CITY OF ALBUQUERQUE

RE: Golden Eagle, 99999 University Blvd. UPC: 101605026829920101
A portion of Tract 18 Artiste, Mesa del Sol
Conceptual Grading and Drainage Plan
Engineer's Stamp Date: 12/15/2023
Hydrology File: S17D001

Based upon the information provided in your submittal received 12/20/2023, the Conceptual Grading & Drainage Plan **is not** approved for action by the DRB/DHO on Site Plan for Building Permit. The following comments need to be addressed for approval of the above referenced project:

Proj. Address: MESA DEL SOL, ALBUQUERQUE, NEW MEXICO  
 Proj. No.: D3794500  
 Date: 2024/01/05  
 Scale: 1" = 50'  
 Drawing No.: **C-00-G-10-03**

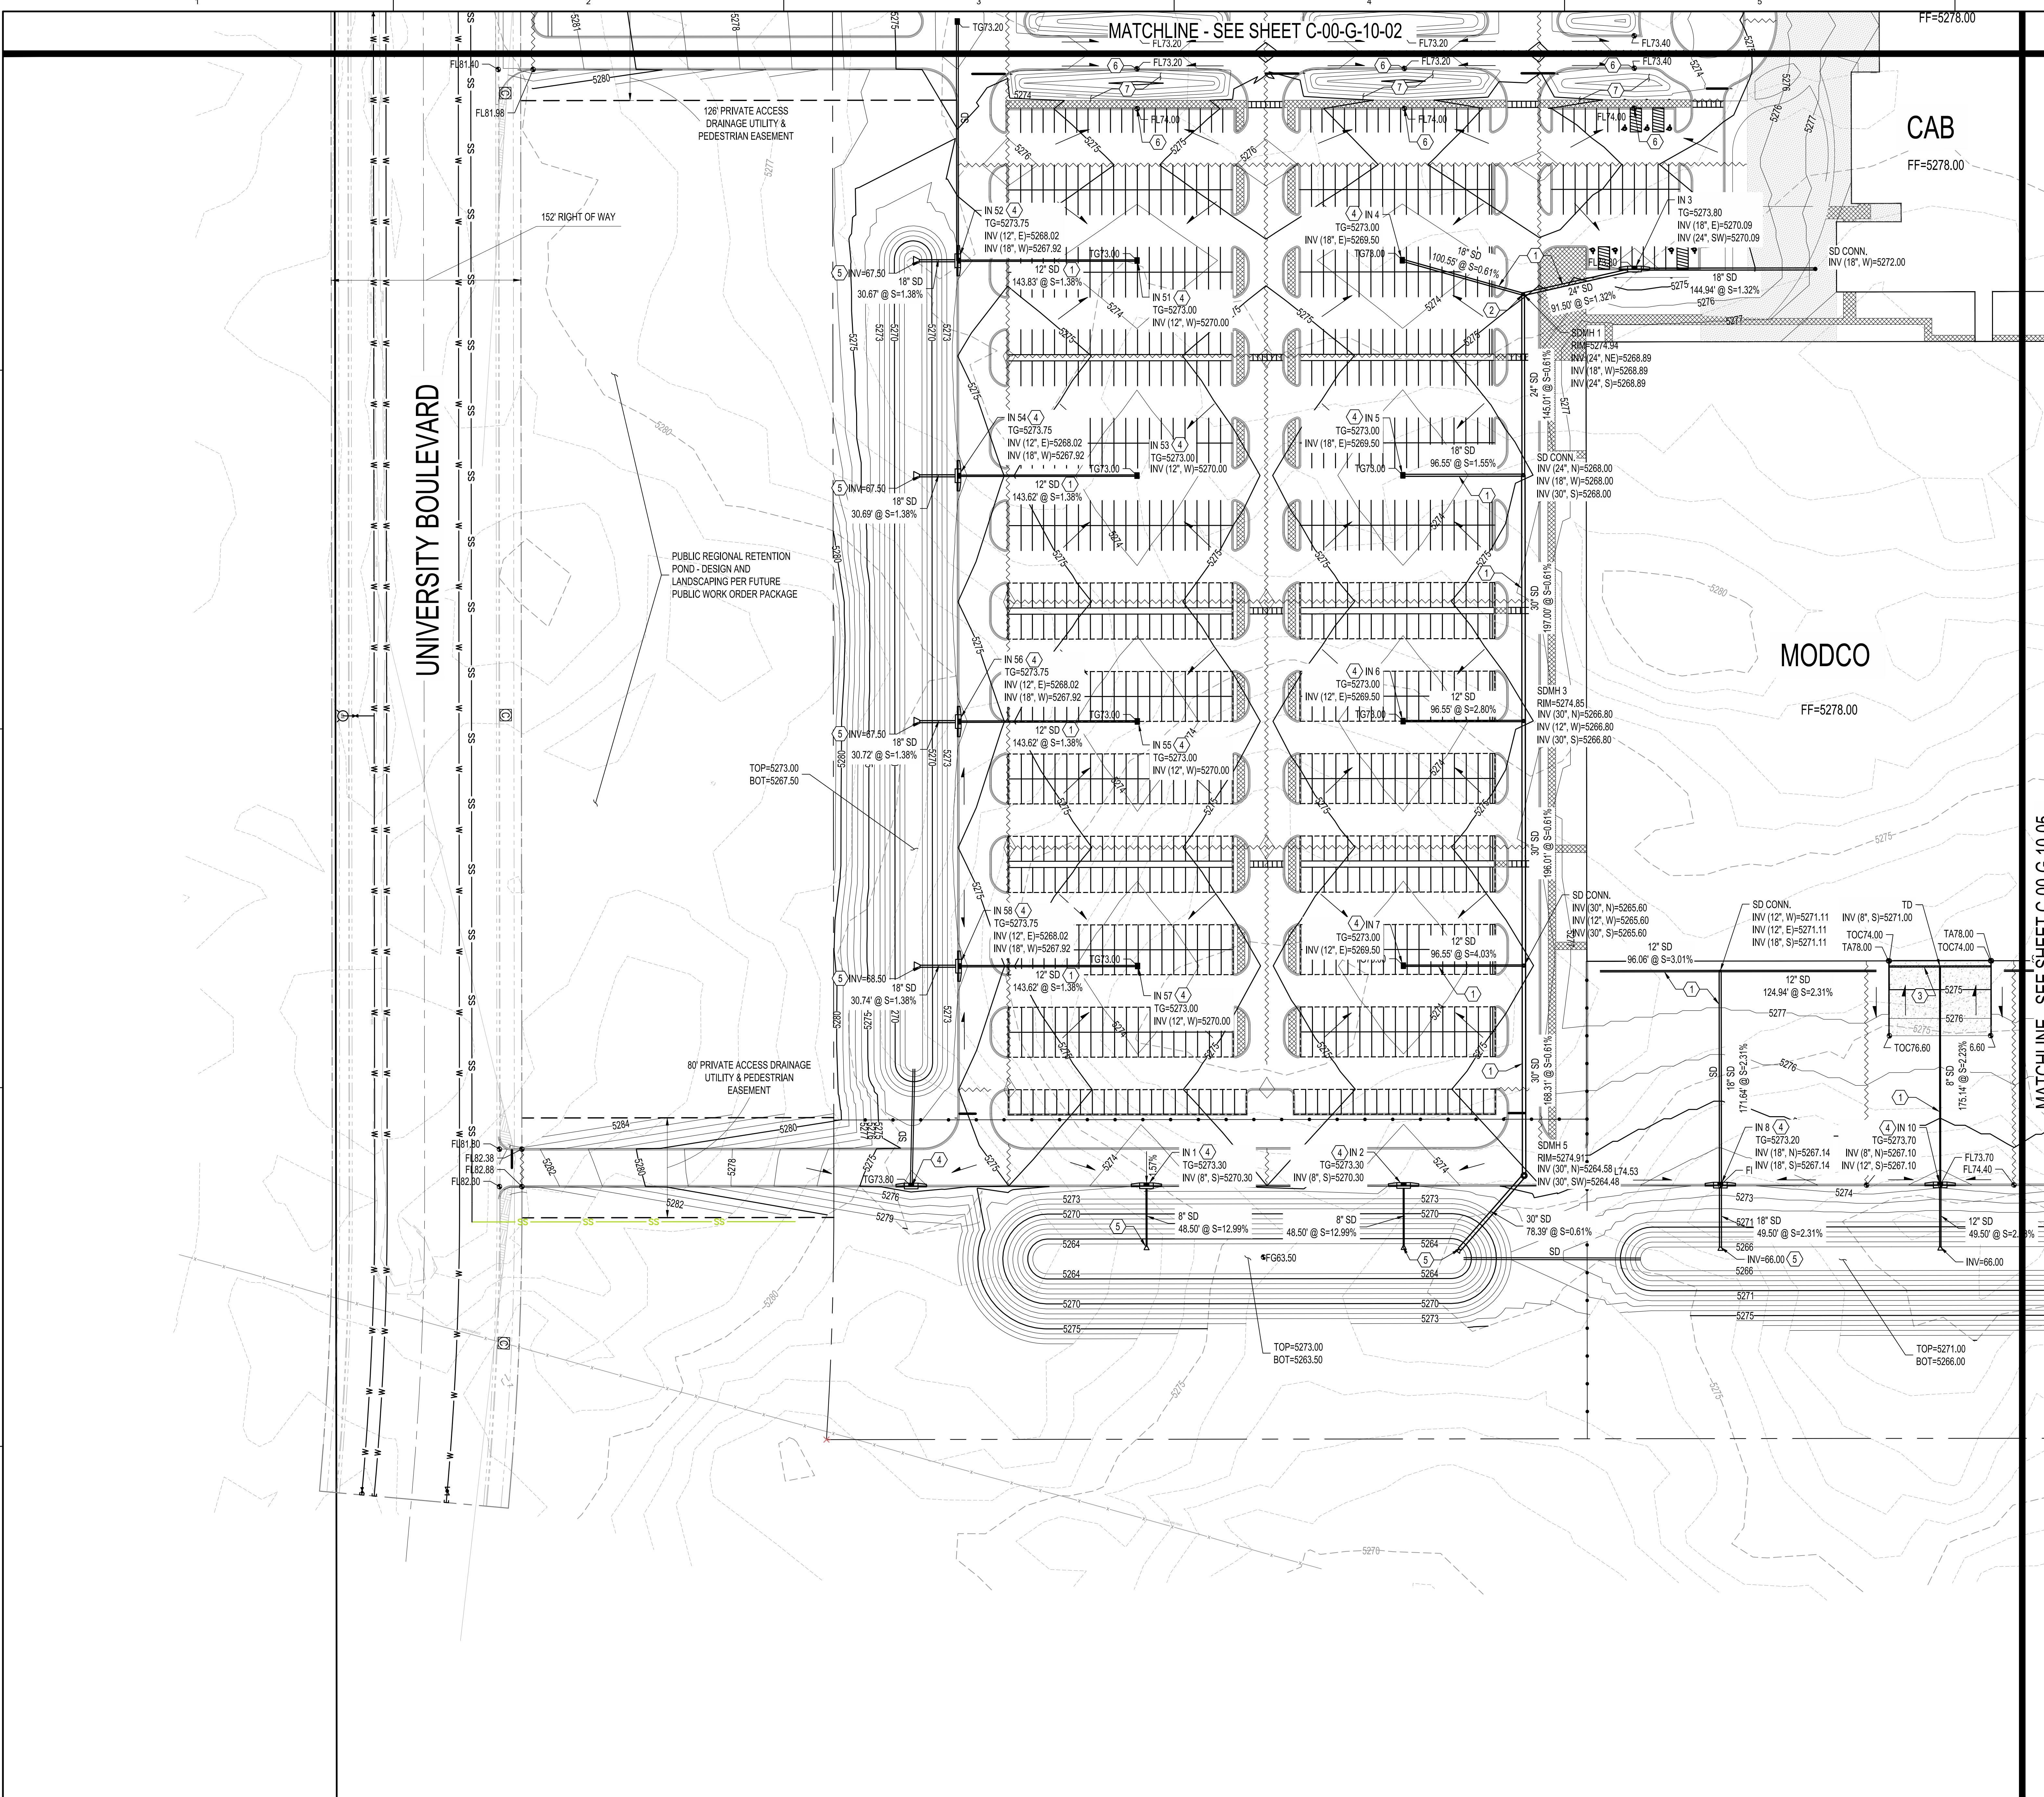
4. Add proposed SD pipe size on the plan.

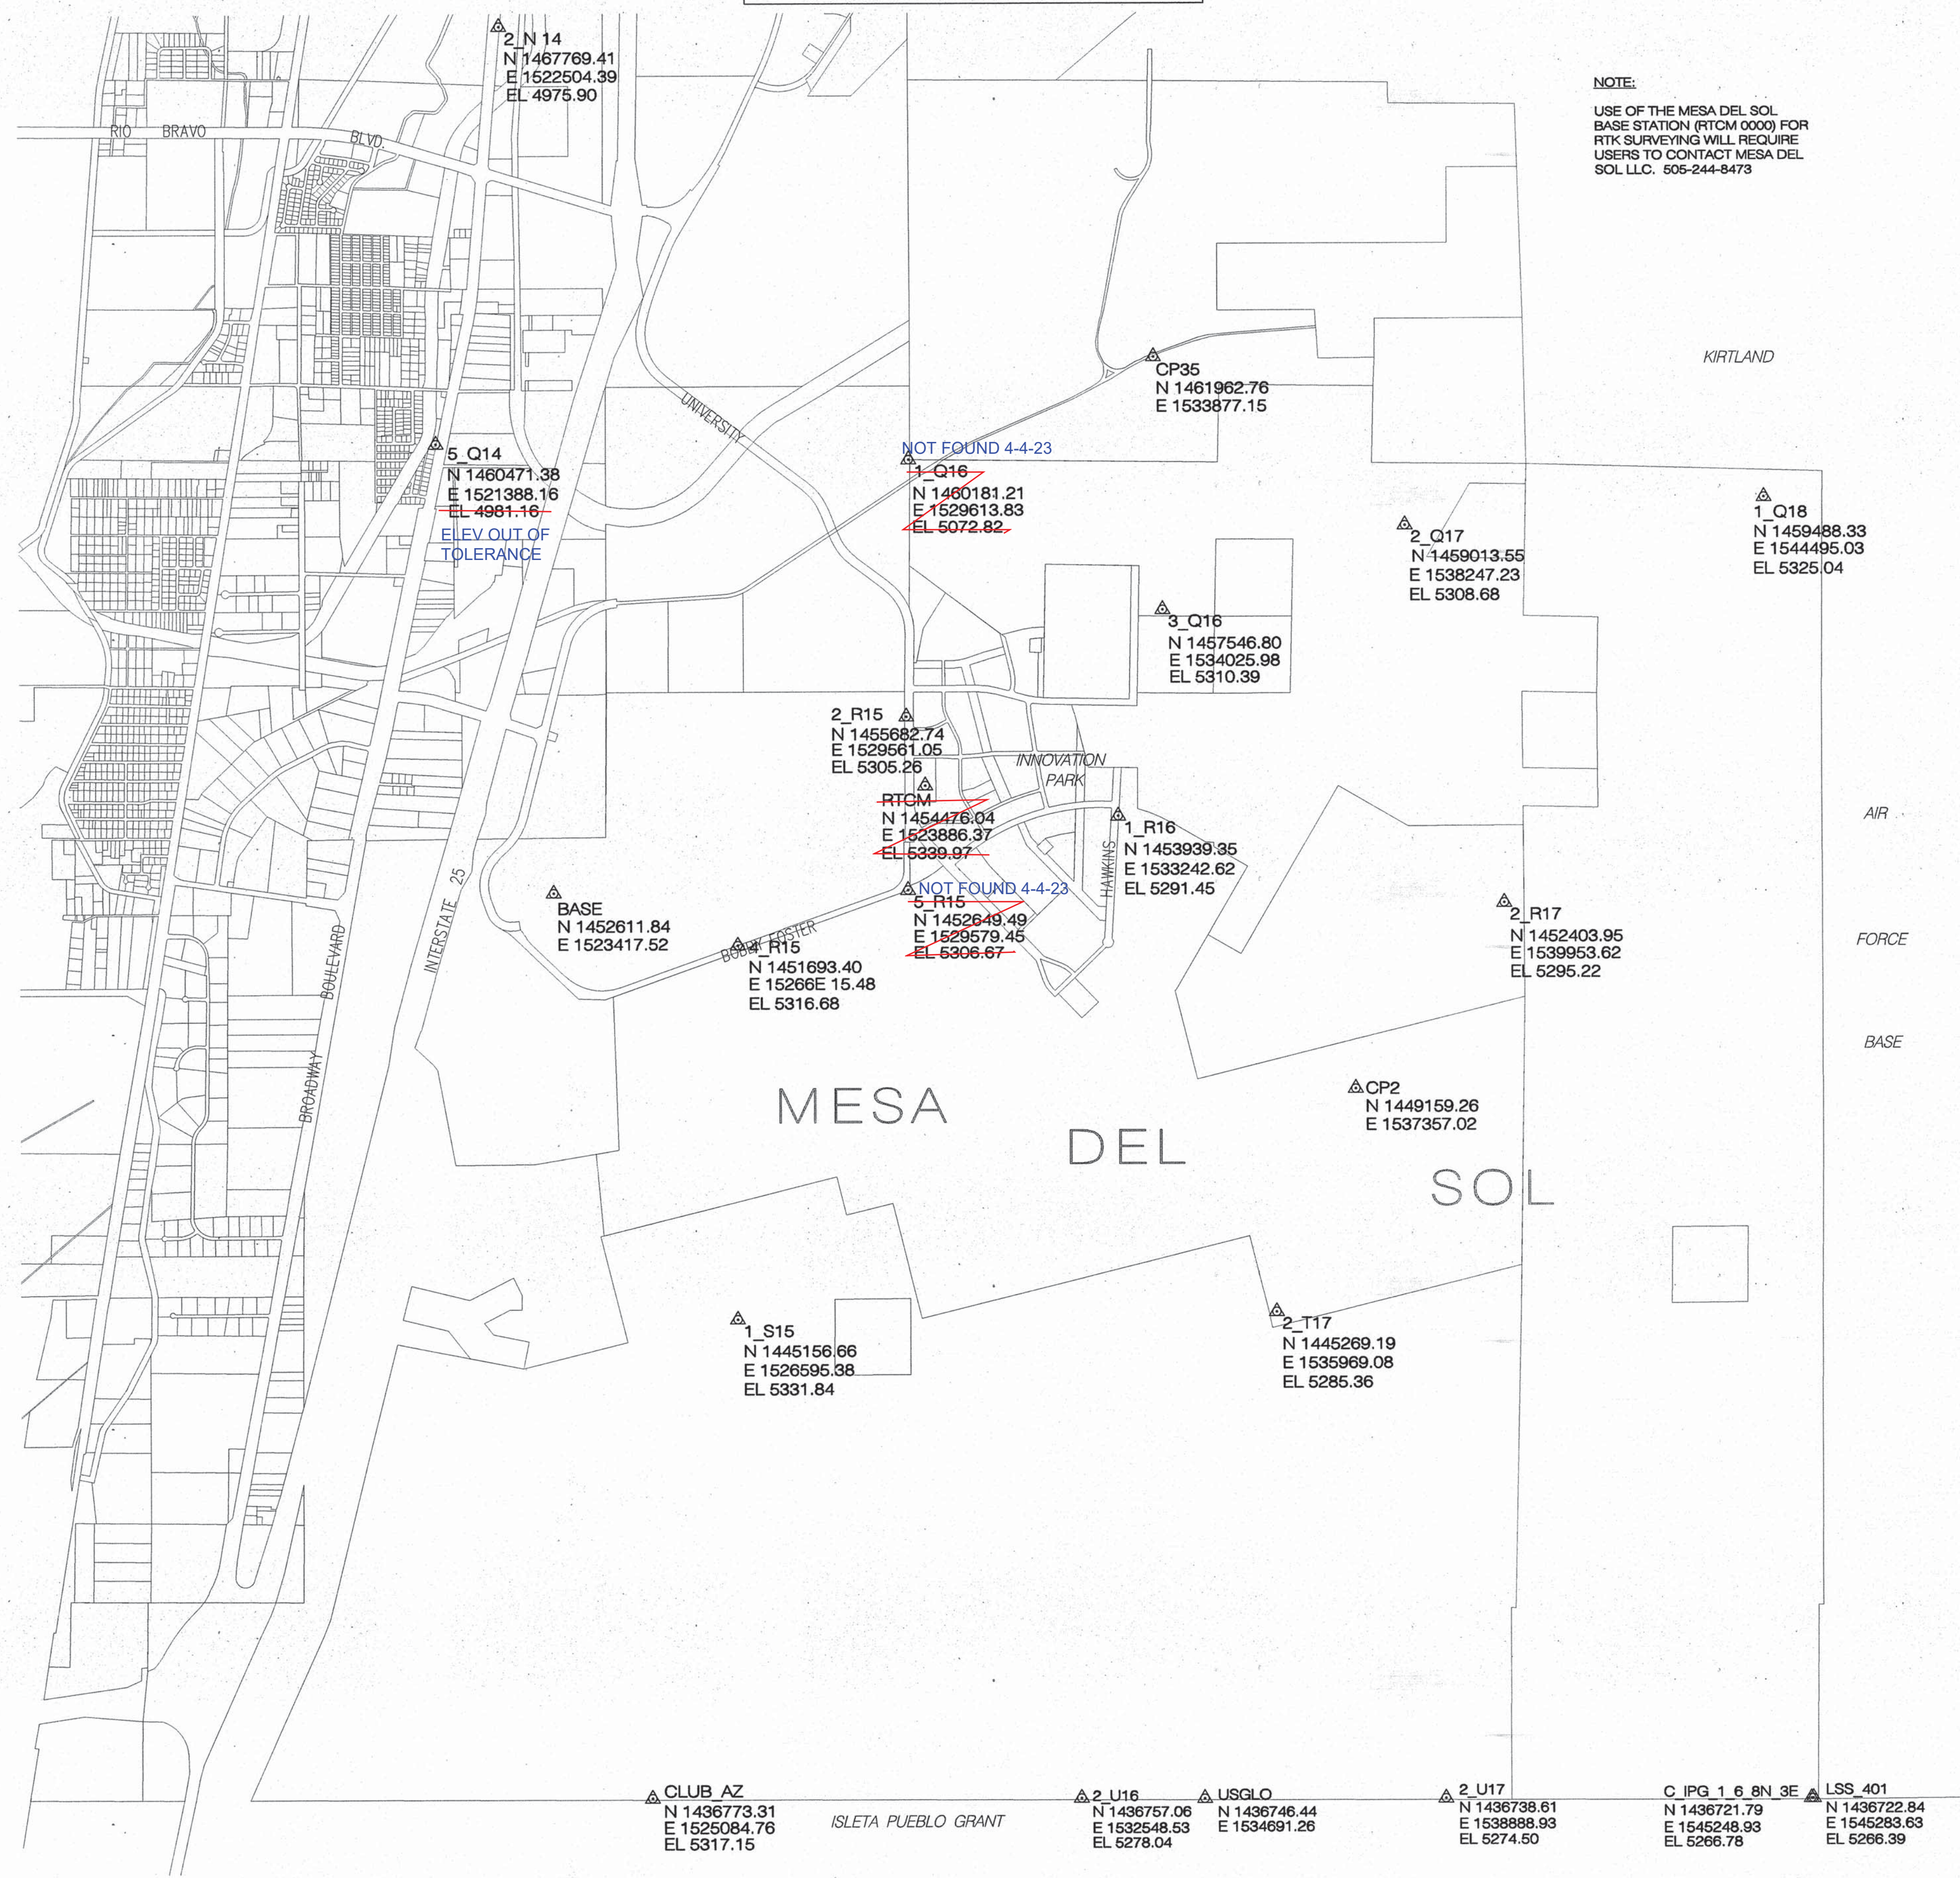
1. Please insert vicinity map and FEMA FIRM map.
2. Provide the Benchmark information (location, description and elevation) for the survey contour information provided.
3. Please verify the 100yr-24hr and 100yr-10day ponding volume calculations for basins 3, 4, 5 and 6 in the basin data table on sheet 7 (Drawing No. C-00-S-10-05). I applied the equations and tables from section 6-2(A) in the DMP, I got the same weighted E values, but my 100yr-24hr and 100yr-10day volume numbers are slightly different than Jacobs.
